Sheringham Shoal and Dudgeon Offshore Wind Farm Extension Projects

Cover Letter - Non-Material Change

March 2023

Non-Material Change Application

Sheringham Shoal and Dudgeon Extension Projects

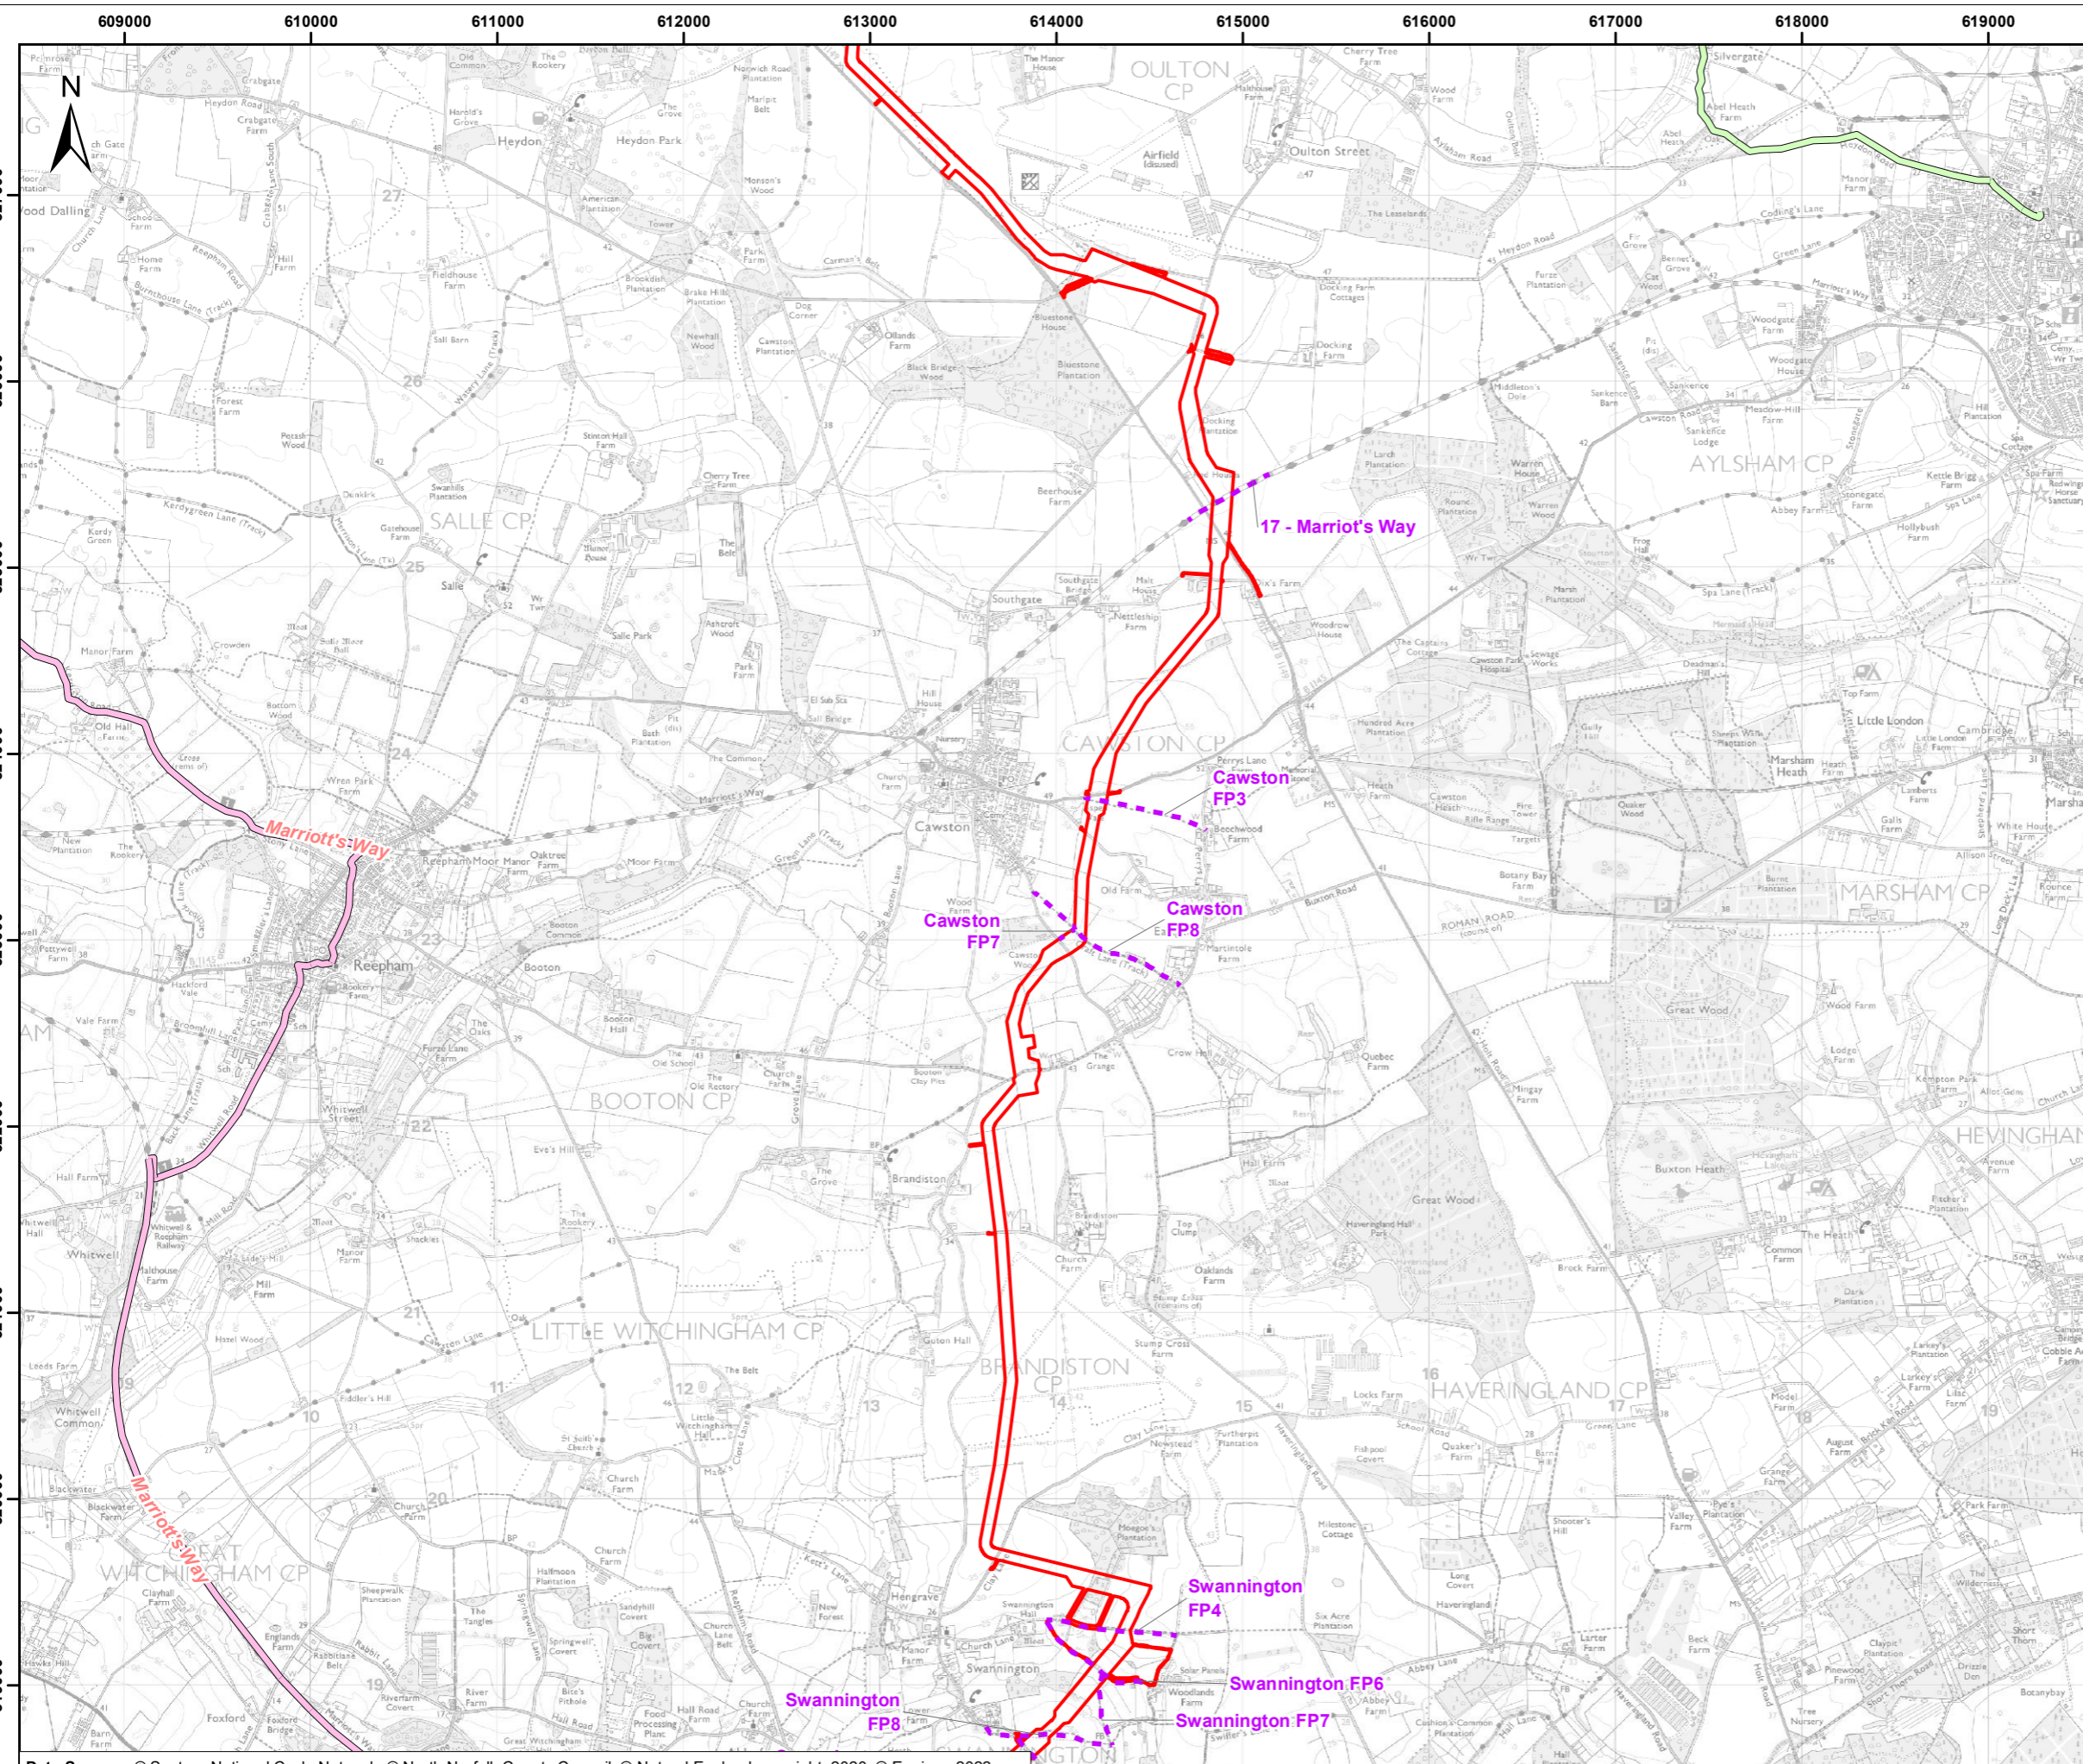
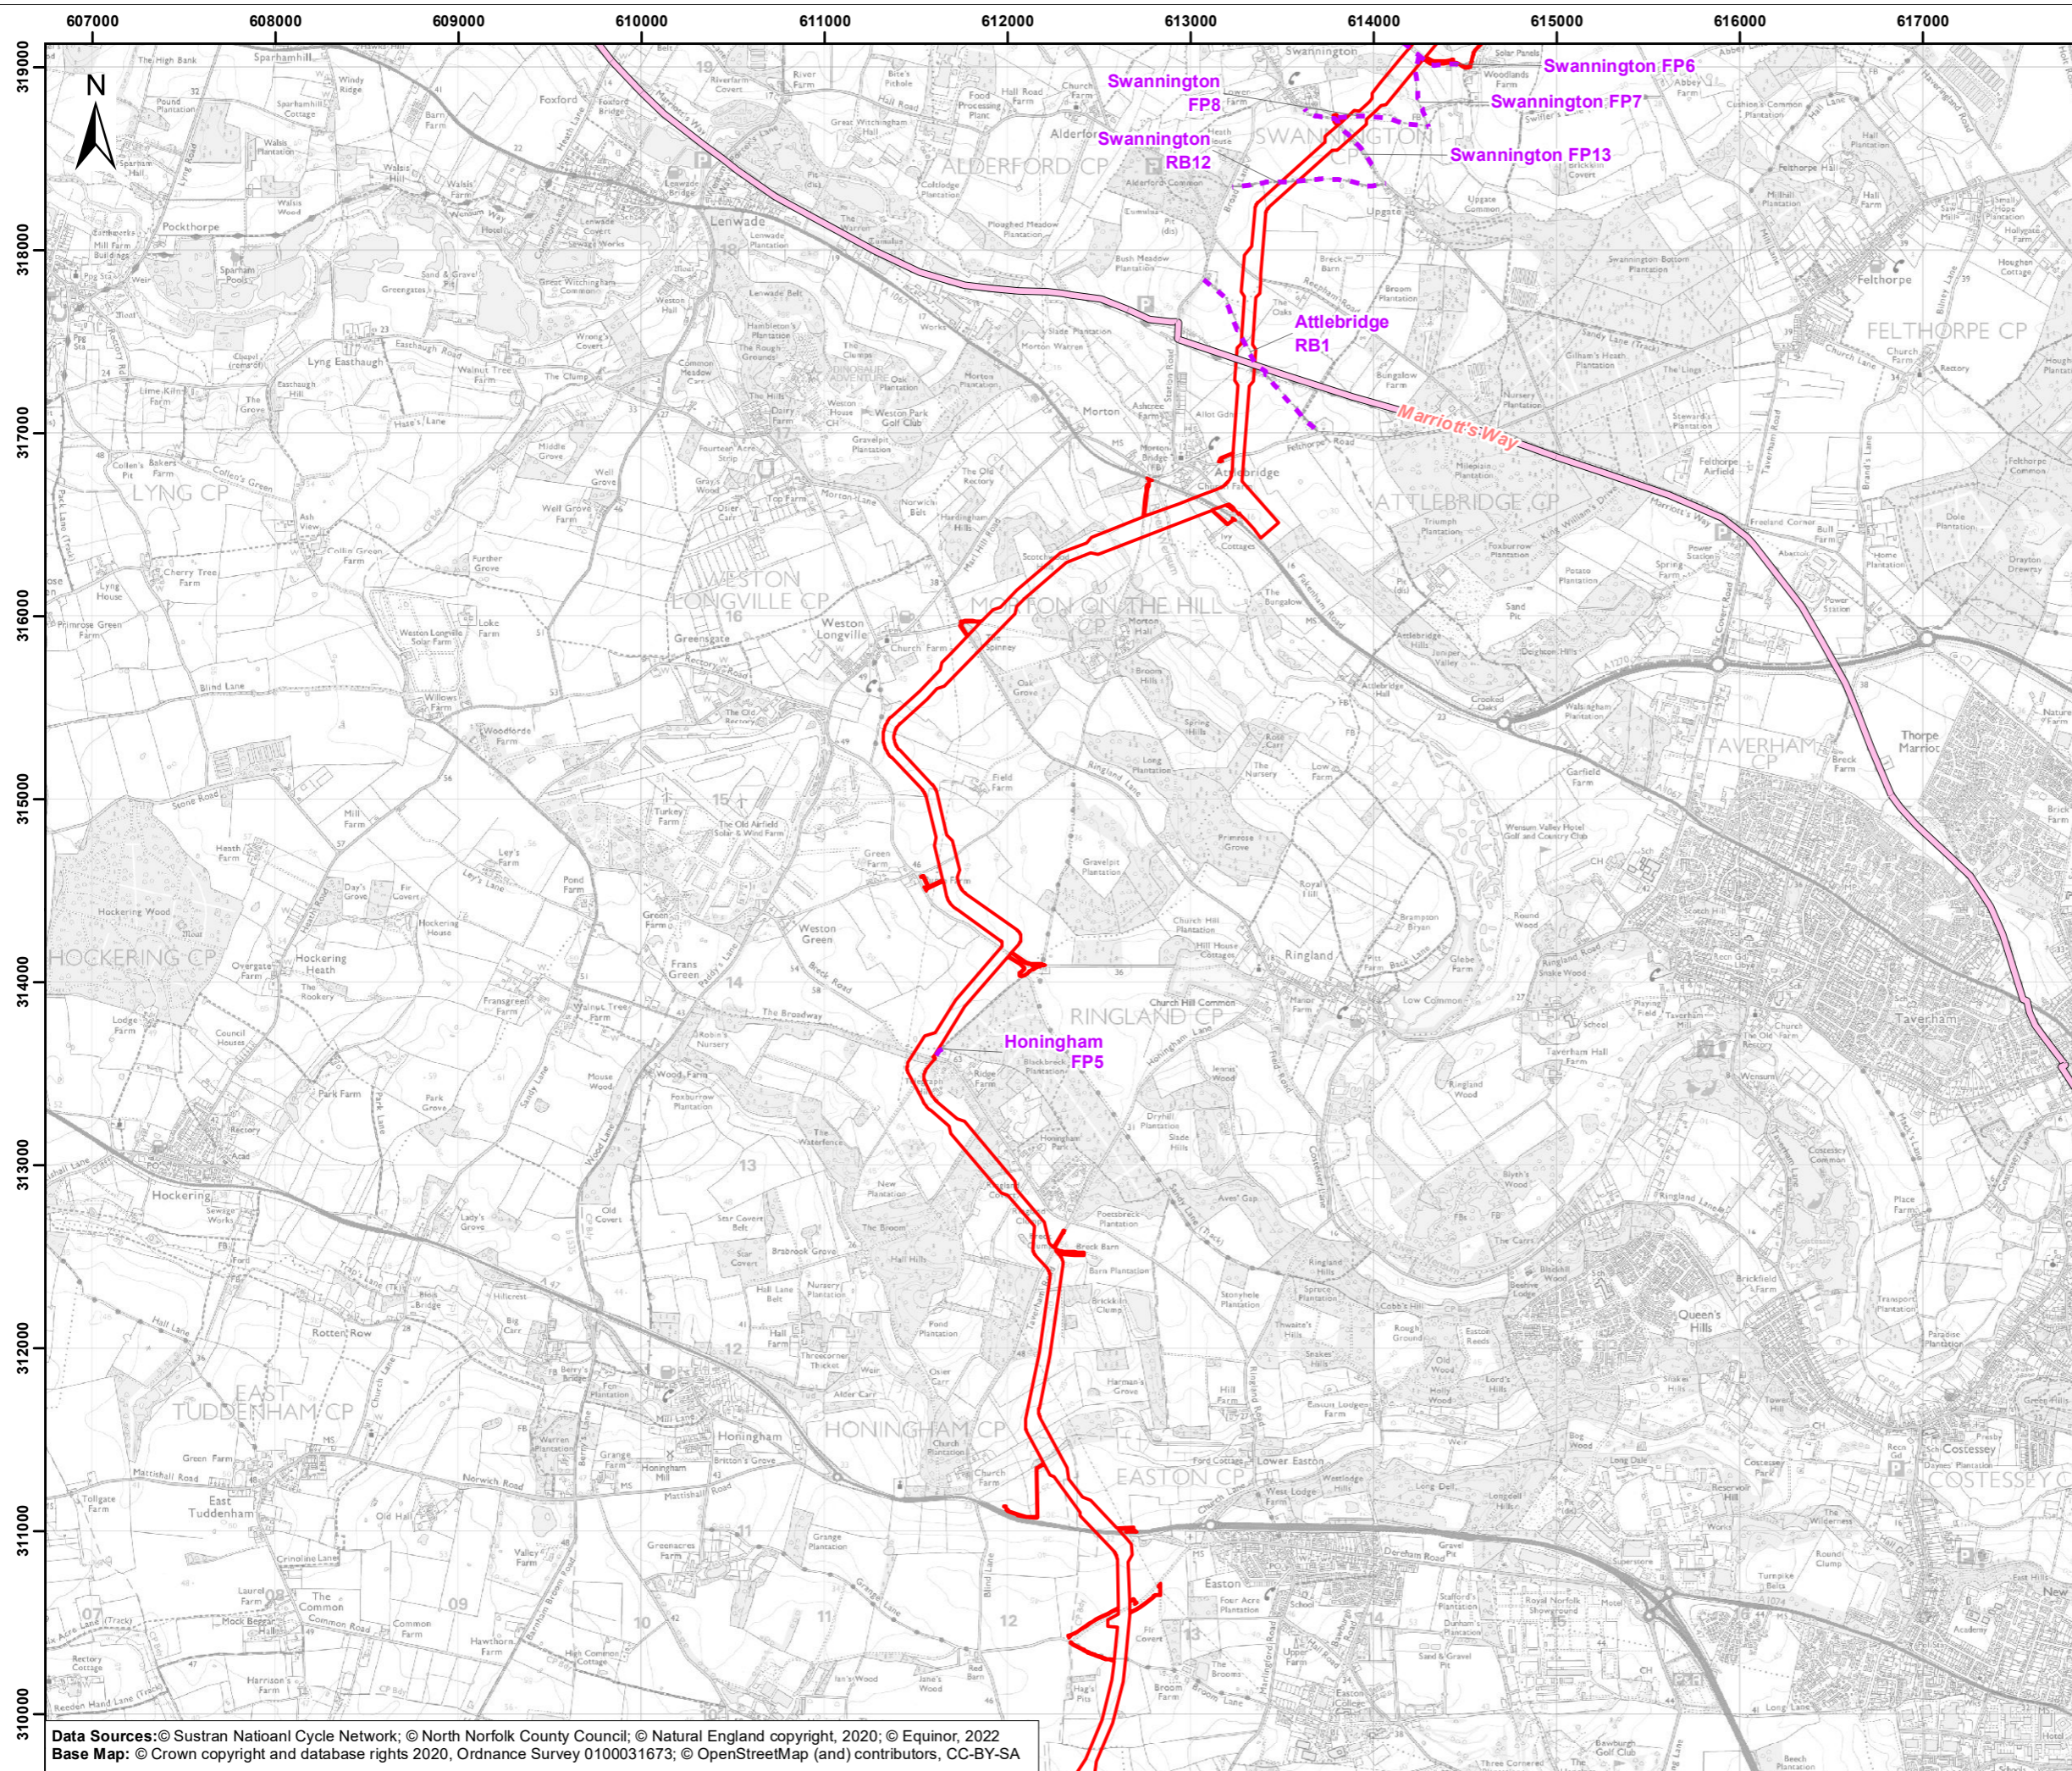
As a result of the changes to the Order Limits to remove the Anglian Water foul sewer connection, **ES Chapter 19 Land Use, Agriculture and Recreation (Revision B)** [document reference 6.1.19] and Figure 19.7 PRoW, Paths and Cycle Routes of **ES Chapter 19 Figures - Land Use, Agriculture and Recreation (Revision B)** [document reference 6.2.19] have been updated to reflect the Public Rights of Way (PRoW) which are located within the Order Limits. The number of PRoW which are intersected by the Order Limits and presented in Table 19-14 of the chapter has reduced. This reduction does not result in a change to the overall assessment and conclusion of likely significant effects presented in the chapter.
